Application Reference: 2026/0505

Site Address: 11 Limes Close, Staincross, Barnsley, S75 6JS

Introduction: This is a householder application which proposes the replacement of an existing single storey side extension (including removal of rear conservatory) with a new 2 storey side extension, erection of single storey front extension, and alterations to rendering to front and rear of dwelling

Drawing No.	Rev No.
MNS001 -004

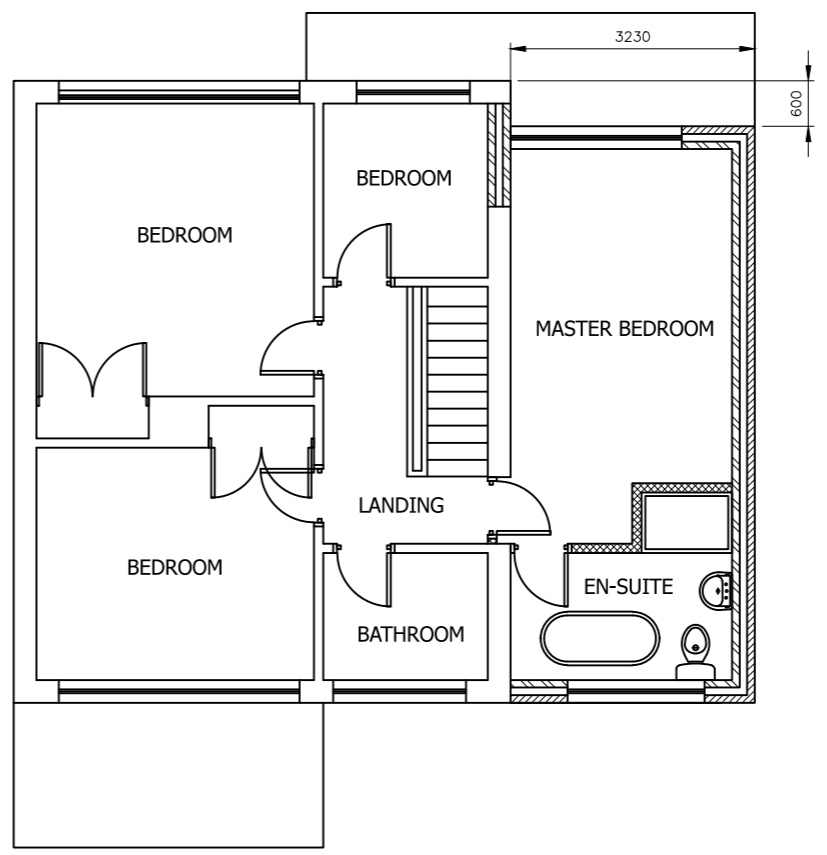
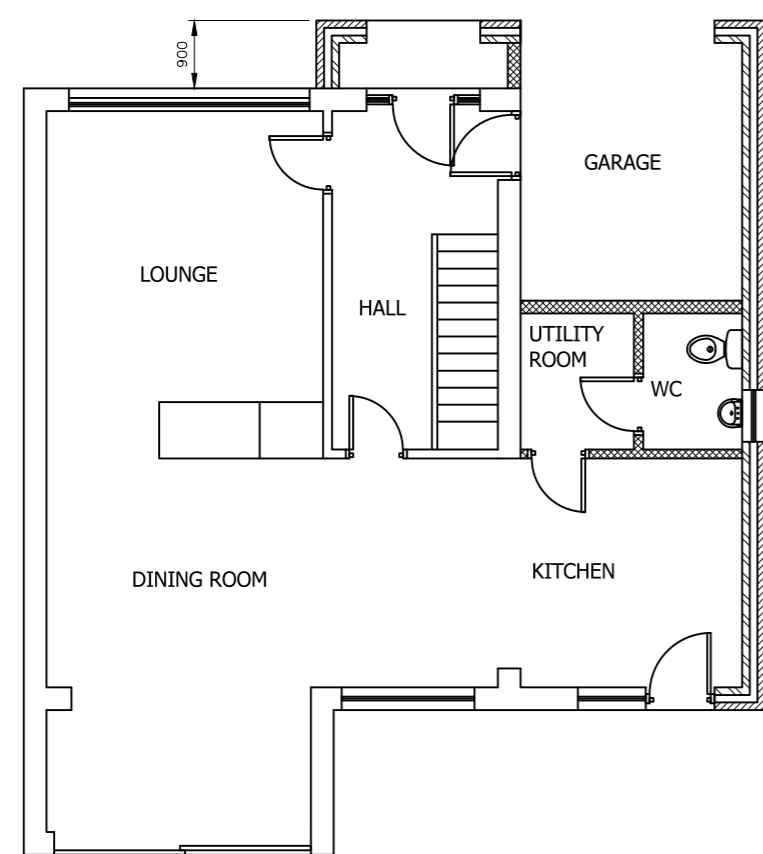
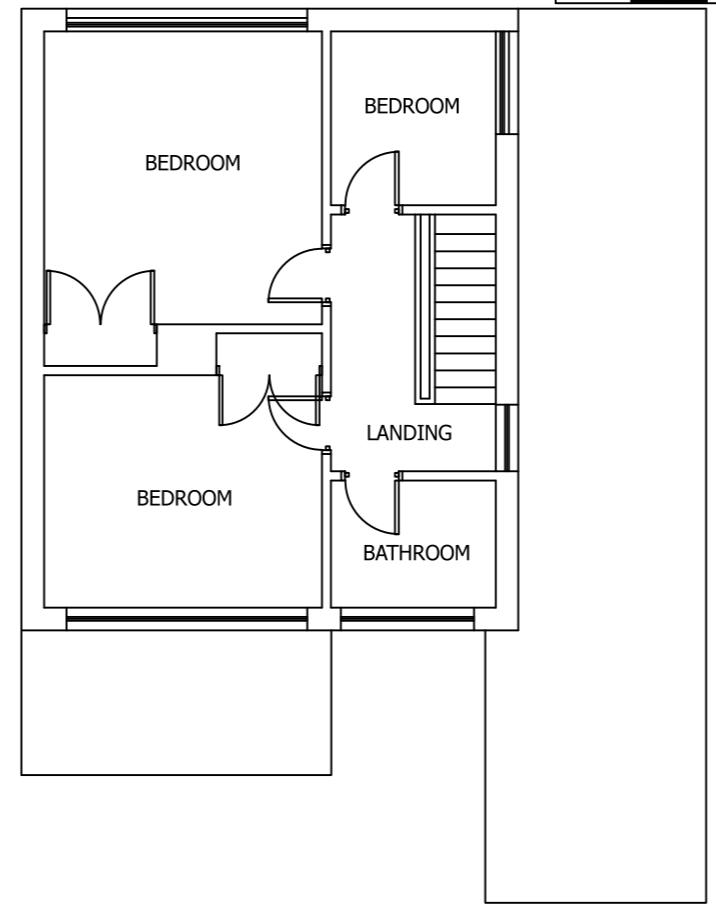
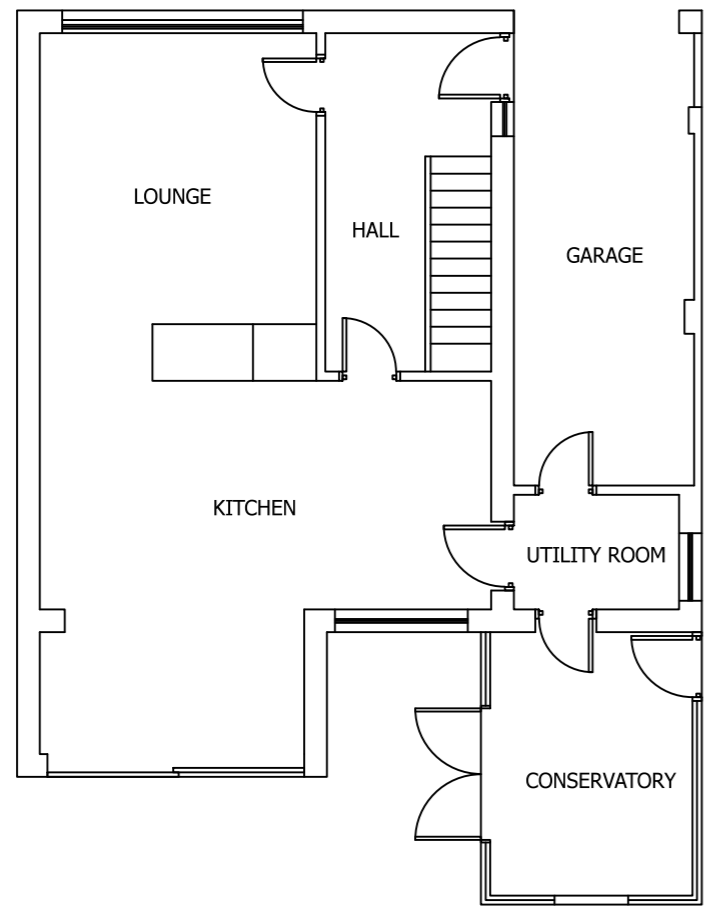
The side extension would provide an additional bedroom and en-suite at first floor and a garage, utility, wc and extended kitchen at ground floor.

In terms of privacy, the proposal does not include any new habitable side windows (one window is shown on the side elevation at ground floor to a wc) which would overlook the neighbouring properties, and the windows to the principle front and rear elevations would not significantly increase overlooking. The neighbouring dwelling, number 9 also does not have any habitable room windows to the side elevation, therefore there would be no significant overbearing impact to this property.

Drawing Title **PROPOSED ELEVATIONS**

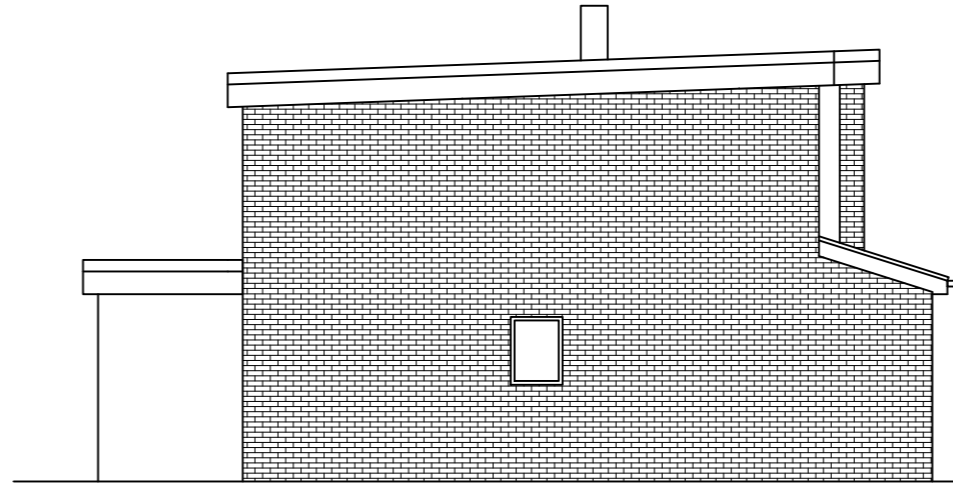
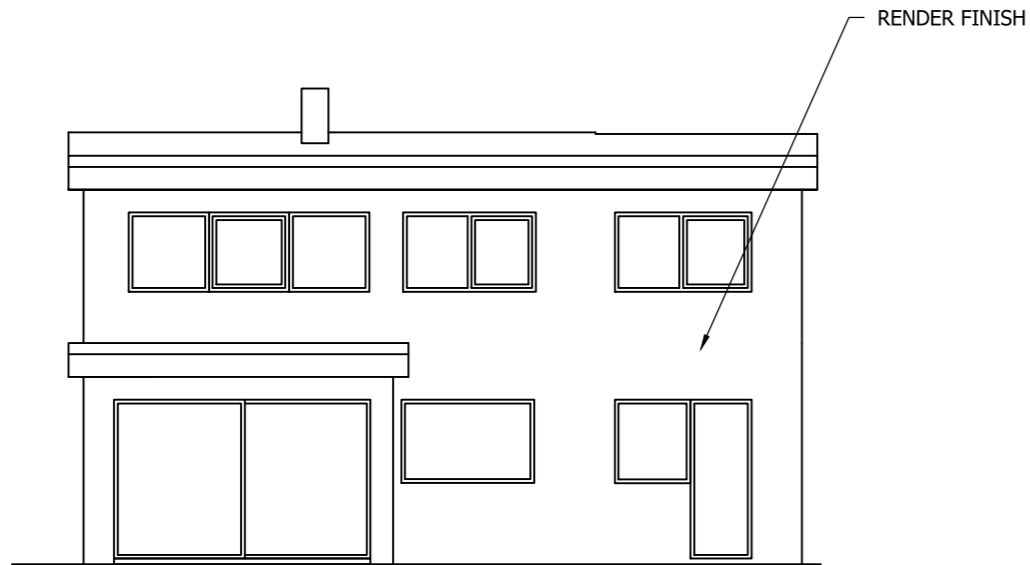
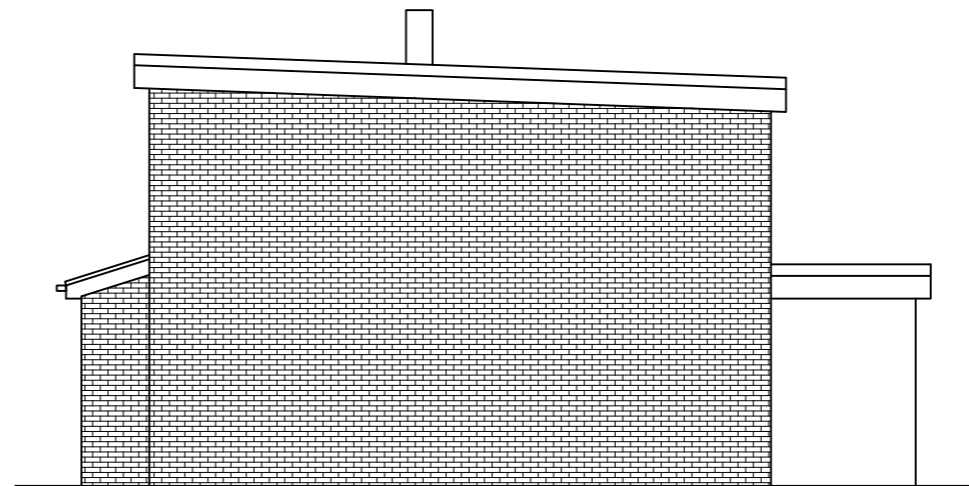
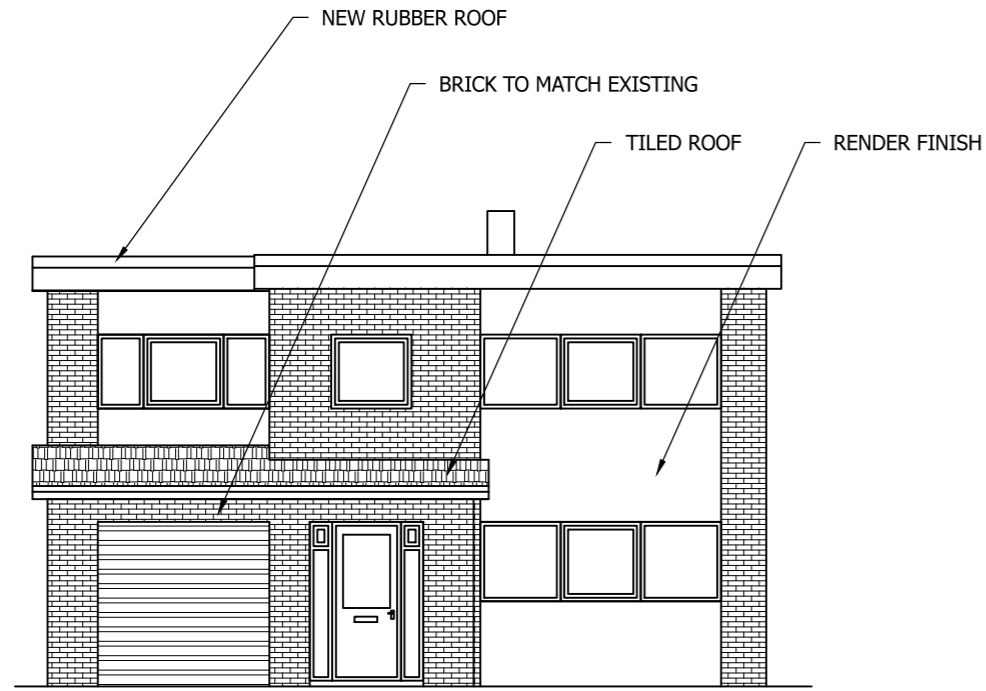
The application proposes the replacement of an existing single storey side garage extension (including removal of rear conservatory) with a new 2 storey side extension with a projection of approximately 3.2m and a set back at first floor level of approximately 0.6m with a corresponding lowered roofline.

In terms of the design and scale of side extensions, the SPD states that:- 'The sideways projection of a two storey side extension should not exceed more than two thirds the width of the original dwelling.' The proposal meets the SPD in this regard and has a matching roof and window details.

The proposal includes a set back of 0.6m from the main front wall of the dwelling. A setback from the front elevation allows for a vertical break in the roof plane and a lowering of the ridge line. In addition to the set-back from the front, the extension is set away from the side boundary to allow access to the rear of the property.

The proposal also includes the erection of single storey lean to front extension to form a porch and extension to the garage, and alterations to rendering to front and rear of dwelling. In terms of the small front projection and the proposed areas of rendering, these are acceptable and would match other similar extensions on the street scene. The proposal is therefore considered to be acceptable in terms of scale and design, and would not harm the visual amenity of the street scene in accordance with the SPD and Policy D1 of the Local Plan. This is afforded moderate weight.
